**Recommended Conditions of Approval - Proposed Waste Processing Facility – Weir Rd,
Teralba – CiviLake Pty Ltd (a business Unit of Lake Macquarie City Council) – Part 3A
EP&A Act 1979**

**Recommended Conditions of Approval -
Proposed Waste Processing Facility – Weir Rd, Teralba –
CiviLake Pty Ltd (a business Unit of Lake Macquarie City Council)**

PART OF DOC10/44121

TERALBA SUSTAINABLE RESOURCE CENTRE
GENERAL ARRANGEMENT

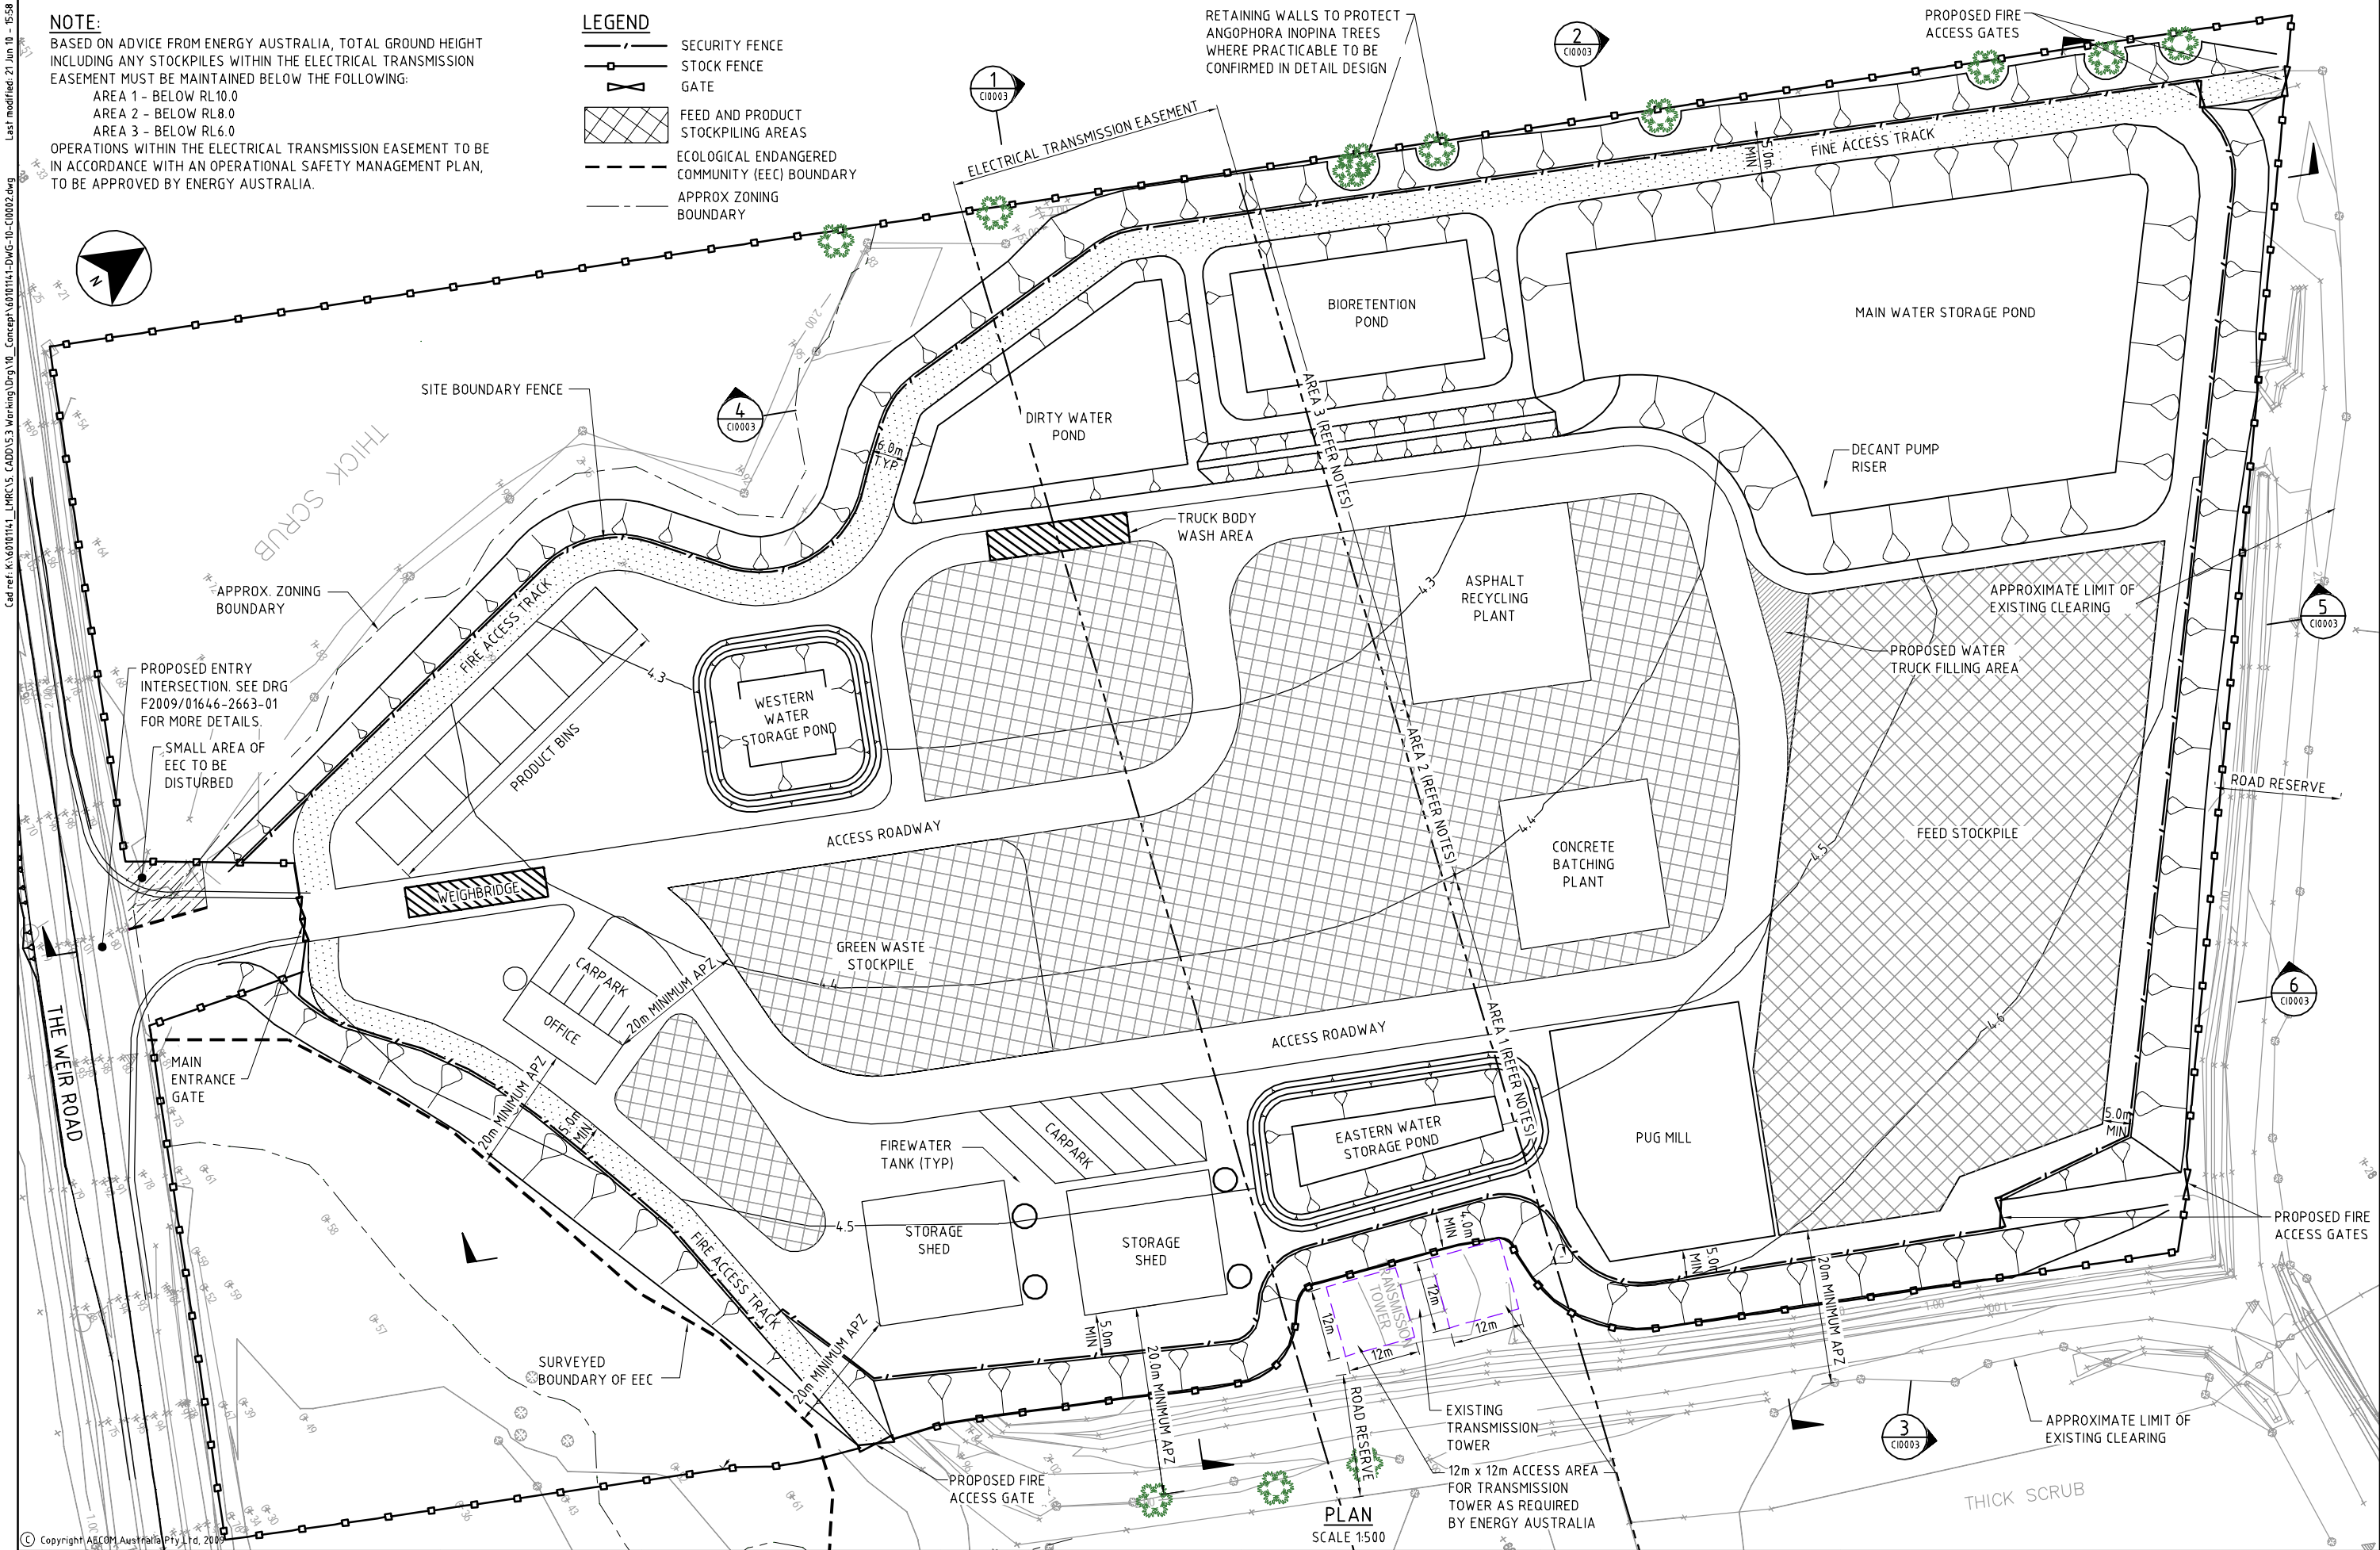
DECCW considers that a key issue is the suitability of the location of the Proposal, specifically the proximity to Cockle Creek and its floodplain and adjacent to a SEPP 14 wetland. DECCW notes that concerns regarding flooding and water quality impacts were also raised in submissions to the NSW Department of Planning in response to the exhibited revised EA.

DECCW also considers that a key issue is the proposed management of waste (including stockpile management) and the location of power lines which pose some ignition risk for combustible material at the Premises.

- (d) ensure filling of the Premises is done in accordance with any requirement(s) by the power line company to which the power easement is owned;
- (e) ensure that the proposed footprint for the Proposal remains within the area depicted in figure 1 titled "Proposed Site layout – Environmental Assessment" by AECOM project ID s70075 dated 24-06-2010.

- (a) prior to waste processing activities occurring at the Premises;
- (b) to a specification which would prevent flood waters entering the Premises from a 1 in 100 year flood event of Cockle Creek; and
- (c) avoids the tree species depicted in figure 1 titled "Proposed Site layout – Environmental Assessment" by AECOM project ID s70075 dated 24-06-2010.

- (a) which is combustible 20 metres or more away from identified bushfire prone vegetation; and
- (b) outside transmission easement zones.
